**Kemps Creek Warehouse, Logistics and Industrial Facilities Hub (SSD-9522)  
Request for Additional Information**

I refer to the Response to Submissions (RtS) for the Kemps Creek Warehouse, Logistics and Industrial Facilities Hub (SSD-9522). Following consultation with Penrith City Council (Council) and relevant government authorities, the Department is requesting that you provide additional information.

## **Attachment 1 - DPIE Industry Assessments and Central (Western) comments**

02 PROPOSED DISTRIBUTER ROAD - SECTION AA
SCALE - 1:200 @ A1

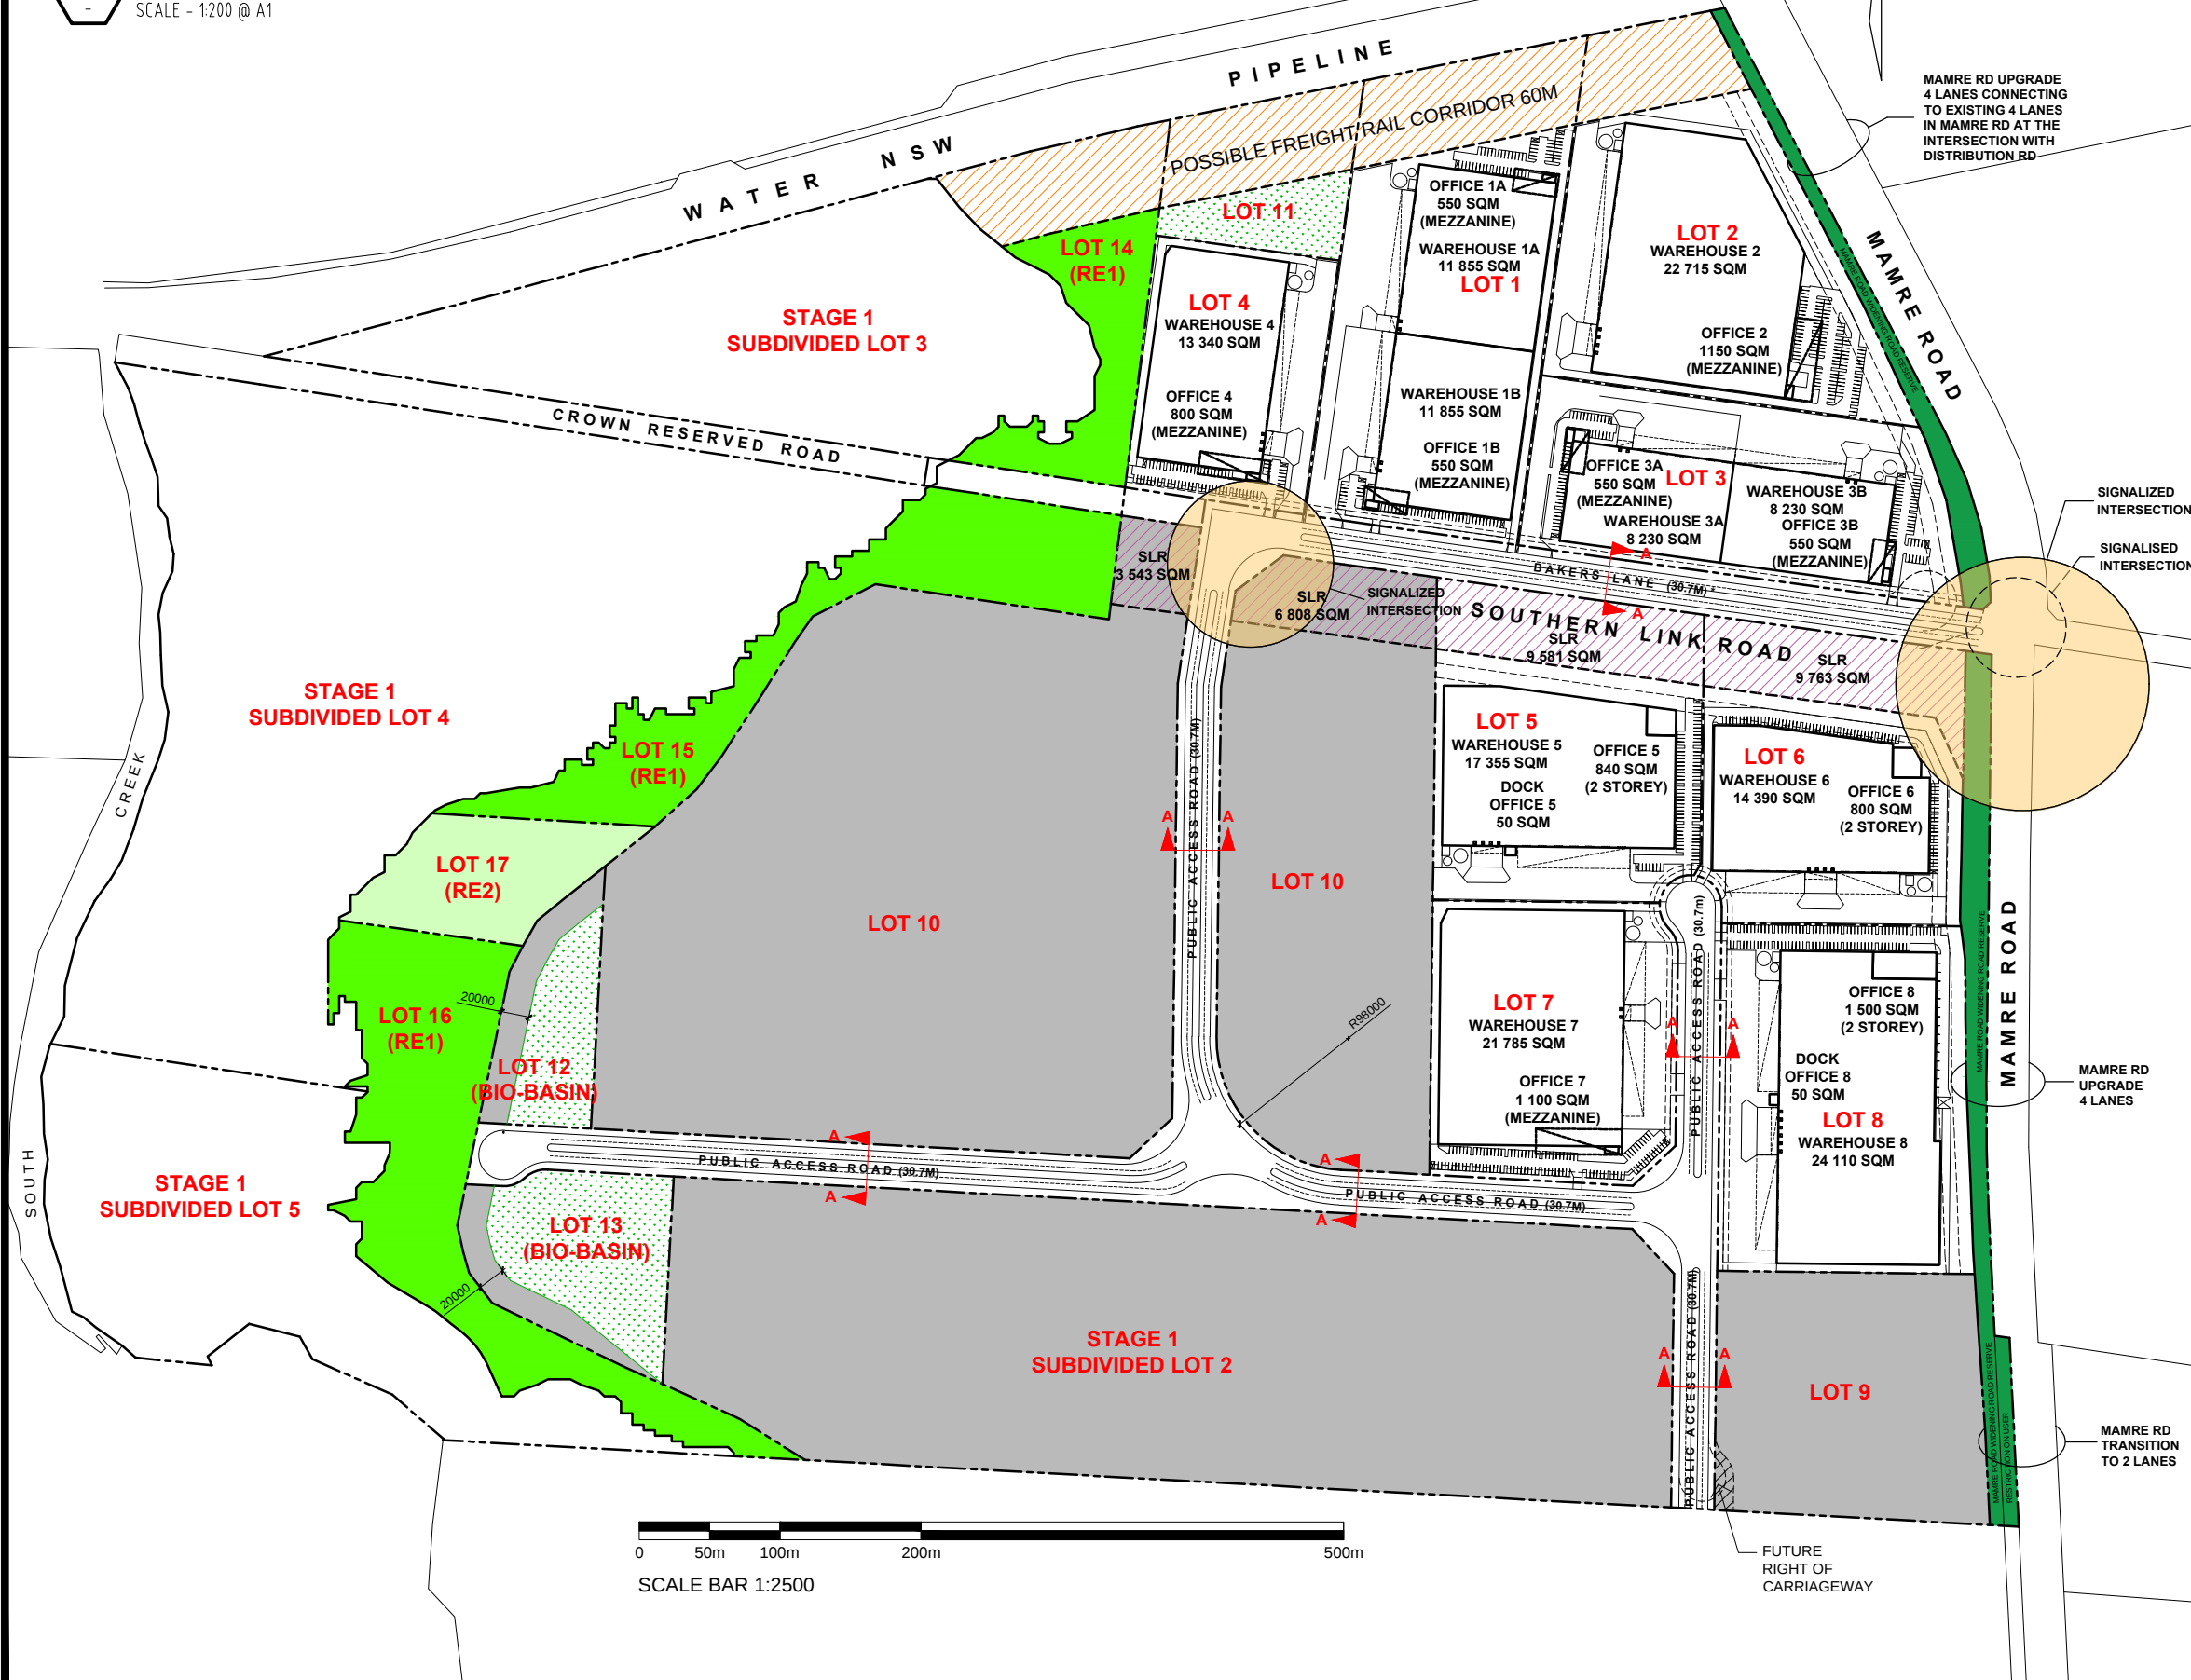
- The north-south road must be designed to cater for a 30.7m road width as identified in the email to the Applicant dated 28 July 2020. A response from a suitably qualified traffic consultant should be provided identifying that the parameters set out in the email dated 28 July 2020 can be achieved on site to create a safe and efficient road design. The submitted traffic assessment does not appear to address each of the points raised in the email.
- Basins should be setback a minimum 20m to enable a future open space road on IN1 land to be delivered.
- The location of the north south road connecting to the property to the south must consider the potential for that property to be developed in the future. The current road location should be moved east to facilitate the future development unless otherwise justified.
